CITY OF PORTLAND, MAINE

August 17th, 2012

Project Name: **Phase II Development Jordan's Meat site**
Project ID: 2012-491 CBL: 29-3-L
Address: 203 Fore Street, Portland
Applicant: Fore India Middle, LLC, Opechee Construction Corporation
Planner: Jean Fraser

MIDDLE STREET LEVEL FLOOR PLAN
SCALE: 3/64" = 1'-0"

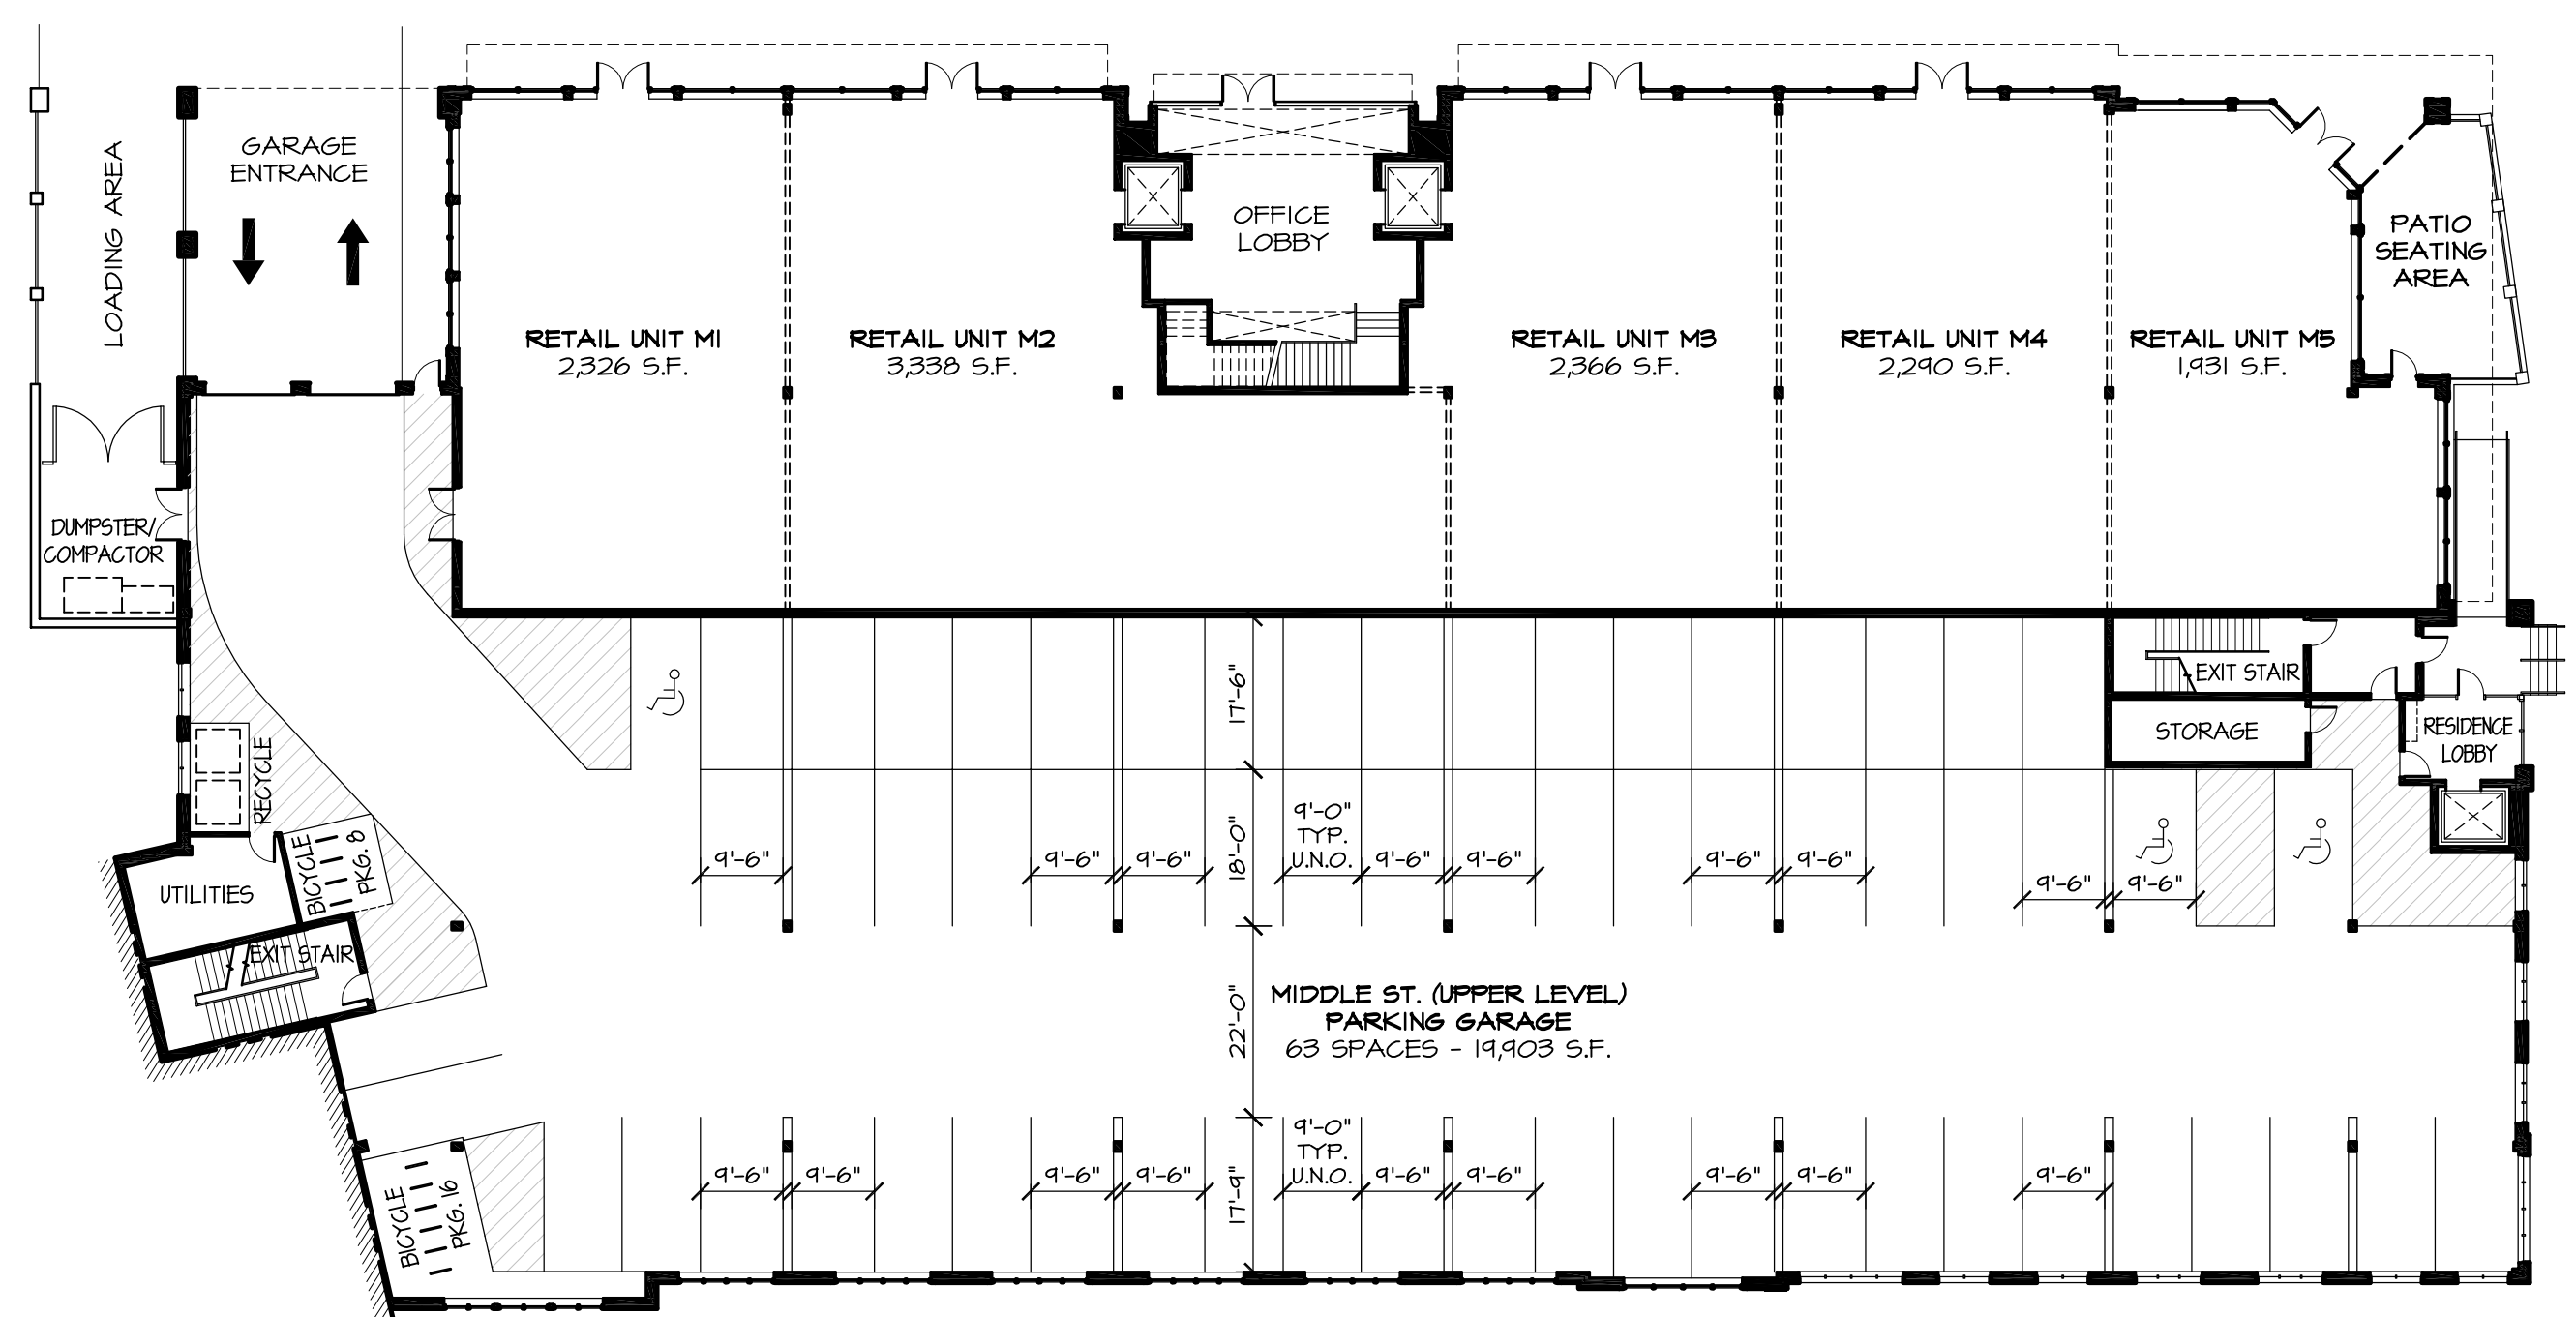
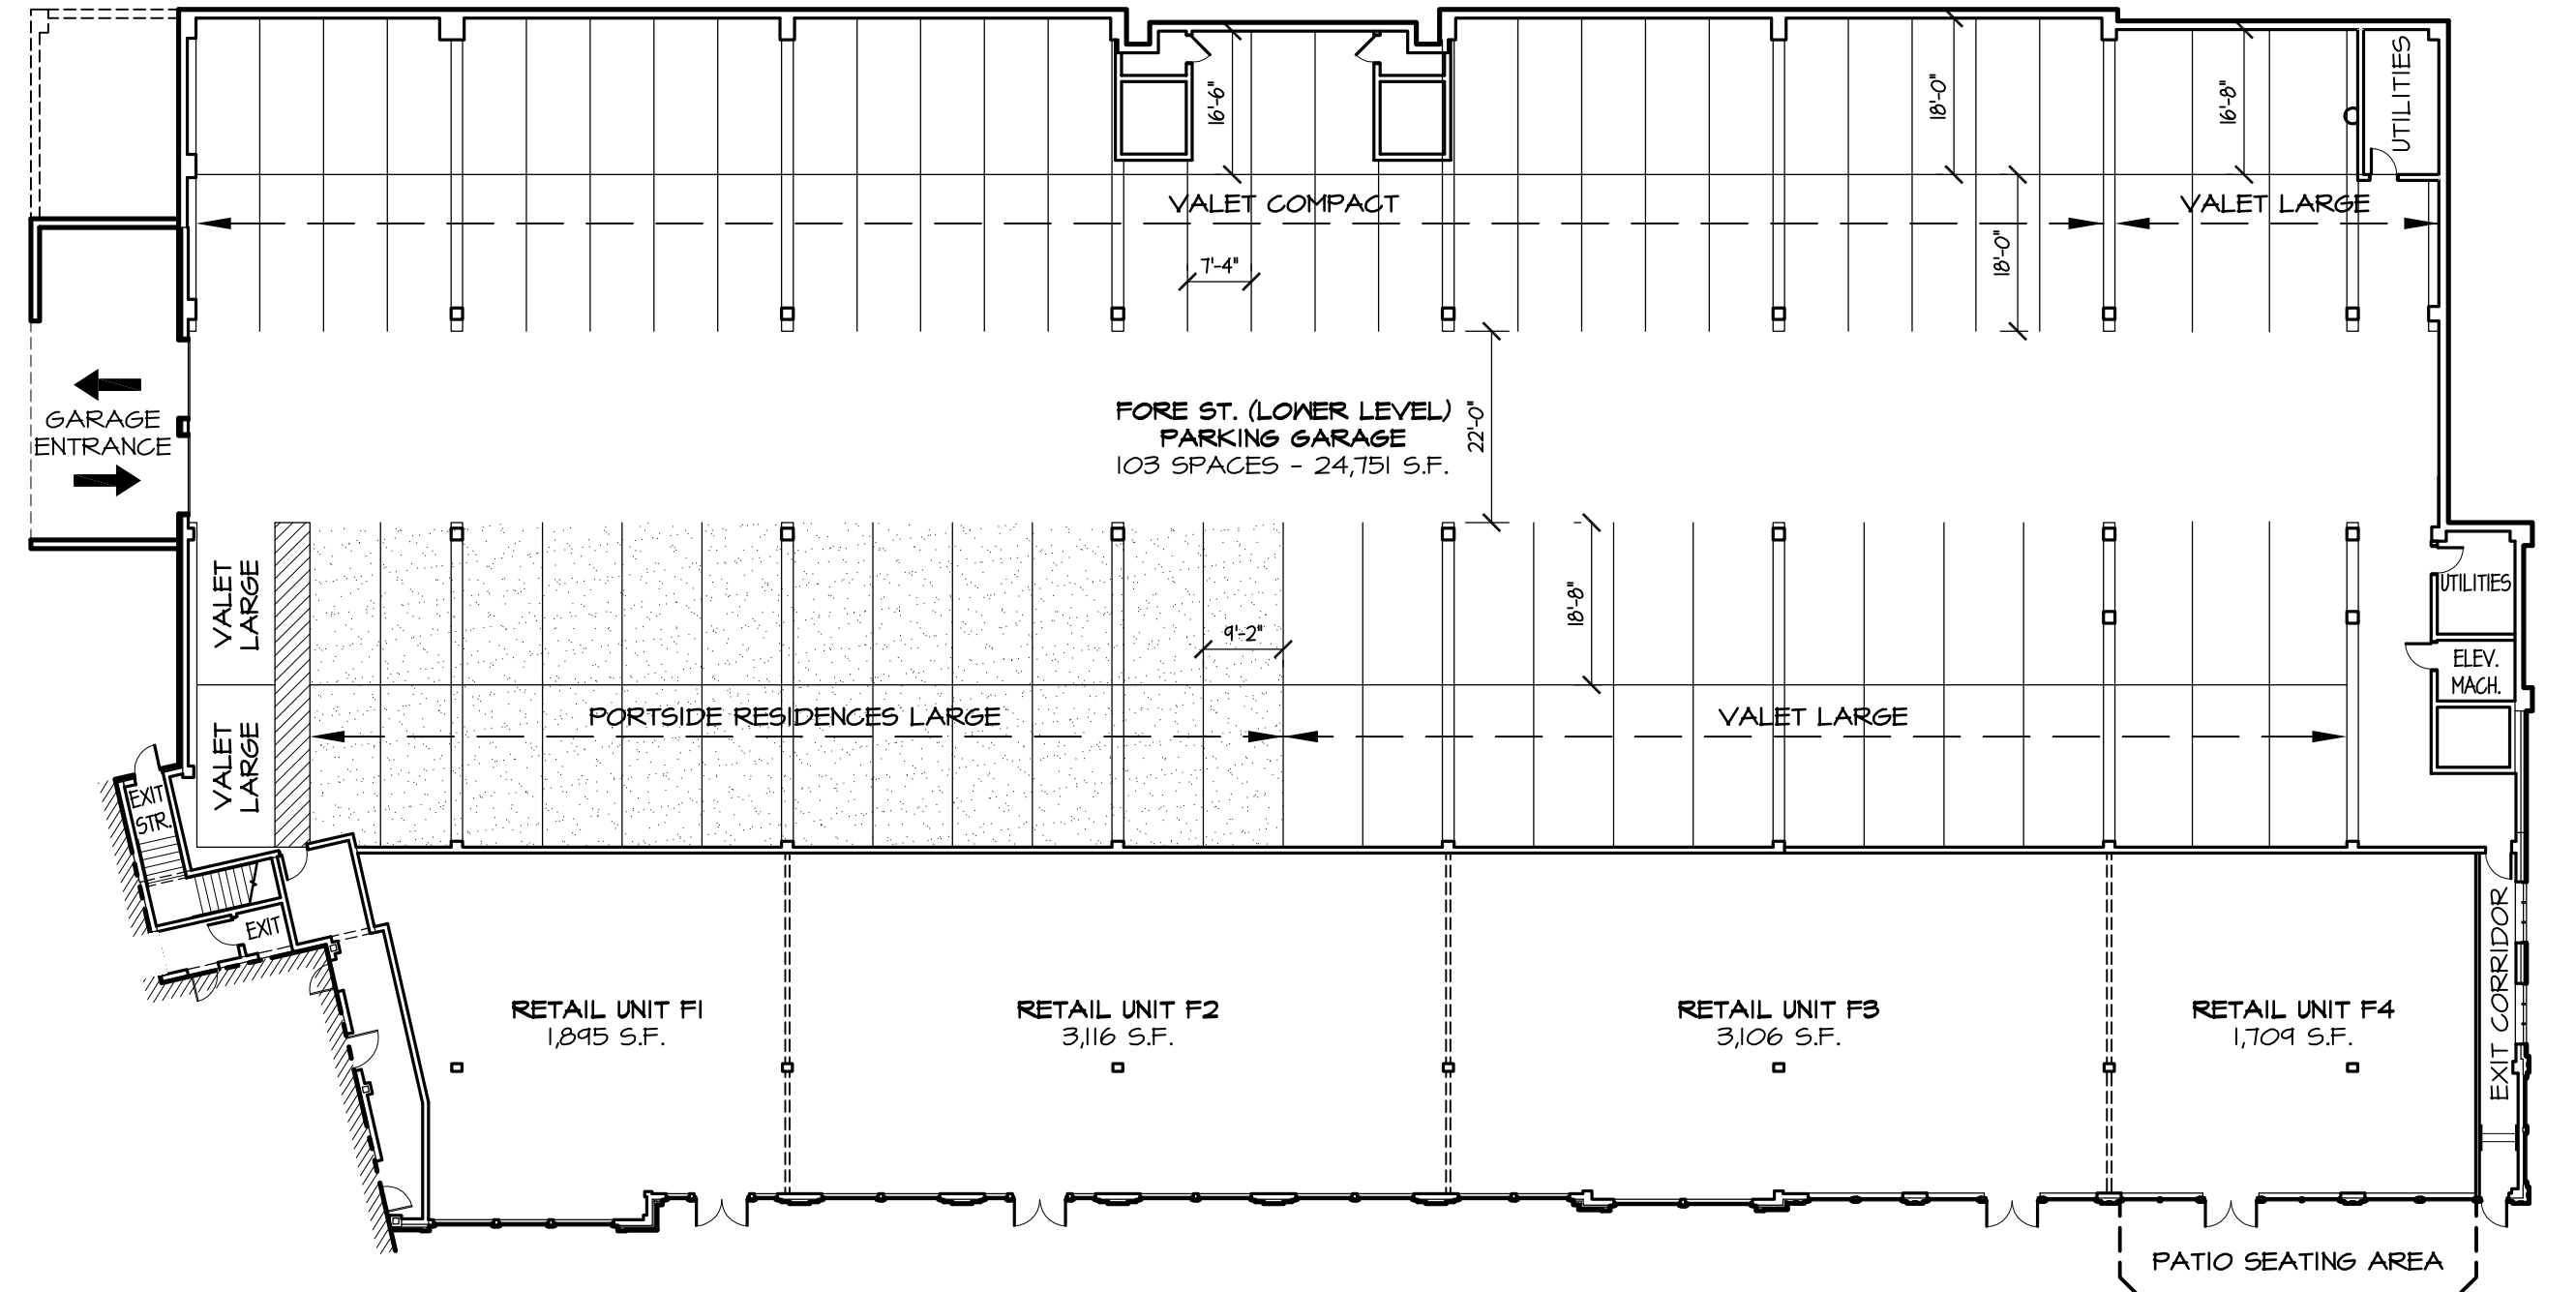
The Planning Board waives Technical Standard, Section 1.14 which requires standard parking spaces to be 9 feet by 18 feet, to allow slightly smaller or larger spaces to take account of the columns and tandem parking arrangements as shown on approved Plan C11 (Plan 13 to this Report), subject to “valet compact” spaces being controlled by 24-hour valet operation.

The Planning Board waives Technical Standard, Section 1.14 which requires compact parking spaces to be 8 feet by 15 feet, to allow the 56 compact spaces in the Fore Street garage (valet –parked) to be slightly smaller or larger to take account of the columns, tandem parking arrangements and because they will only be used for 24-hour valet parking as described in the *Updated Parking Study* and shown on approved Plan C11 (respectively C.3 and Plan 13 to this Report).

The Planning Board waives Technical Standard, Section 1.14, Figure I-27 and I-29 which requires a 24 foot wide drive aisle, to allow the reduction to 22 feet in both garages to accommodate structural columns, based on the parking use being limited to 24-hour valet and regular users where depicted on the approved Plan C11 (Plan 13 to this Report).

- o The applicant is proposing compact parking spaces that are slightly narrower and slightly longer than City standards. Given that the parking spaces will be used by valet services, I support a waiver from the City's Technical standard.

- o The applicant is proposing a greater percentage of compact parking spaces as allowable by City standards (49% vs. 20%). Given that the parking spaces will be used by valet services, I support a waiver from the City's Technical standard.

- o The applicant is proposing tandem parking stalls that have a shorter length (17.5 feet vs. 18 feet) as compared to City standards. Given that the parking spaces will be used by valet services, I support a waiver from the City's Technical standard.

- o The applicant is proposing parking stalls that have a shorter length (17 feet 9 inches vs. 18 feet) as compared to City standards. Given that the parking spaces will be used by valet services, I support a waiver from the City's Technical standard.

- o The applicant is proposing parking aisle widths that will be narrower (22 feet vs. 24 feet) than City standards require. While parking maneuvers will be tight, I support a waiver given that the Fore Street parking level will involve experience valet parking personnel, and the Middle Street parking lot is relatively small and slow vehicle maneuvering activity should not result in widespread issues.

- o Some parking spaces on the Middle Street level exceed the width standard (9.5 feet vs. 9 feet) allowed and therefore a waiver is required. Given that structural support columns are located in the areas where these wider parking spaces are proposed, I support a waiver from the City Technical standards.

- o Some parking spaces in the India Street level exceed the width standard (9 feet 2 inches vs. 9 feet) and a waiver is required. I support a waiver from City standards.

- o Some parking spaces in the India Street level exceed the length standard (18 feet 8 inches vs. 18 feet) and a waiver is required. I support a waiver from City standards.
